To: Jim Manhart, Harnett County Environmental Health Department
From: Sloan Griffin, Advanced Septic, Inc.
Date: June 1, 2017
Subject: System alteration proposal for 25 Kinnis Creek Drive

Repair System Layout

Harnett County Department of Public Health Site Sketch

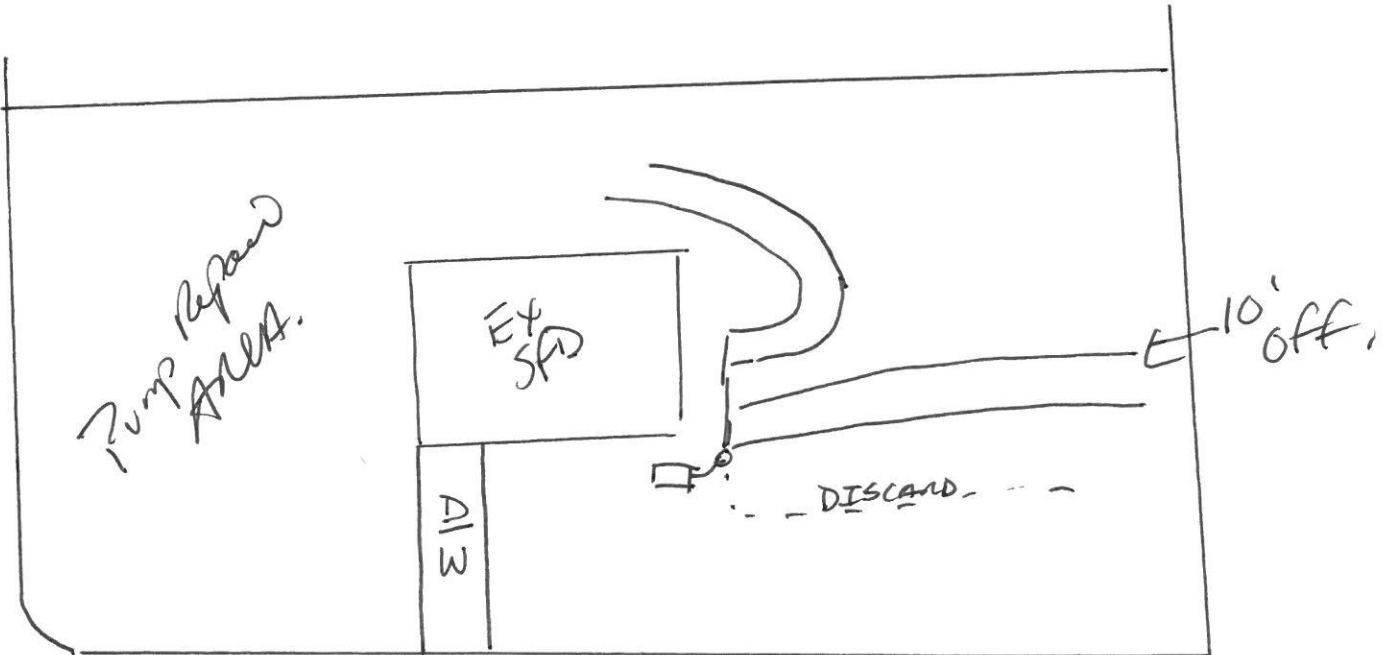
- 1) Abandon the attempted drainfield lines and install two 60' gravel lines on contour as denoted by the purple lines on the drawing. Suggested max trench bottom depth is 20 inches.
- 2) Shorten the existing 100' lines to 60' and maintain 10' setback off the property line utilizing bentonite dams.
- 3) Confirm condition of septic tank and install sanitary tee with effluent filter if not already provided.
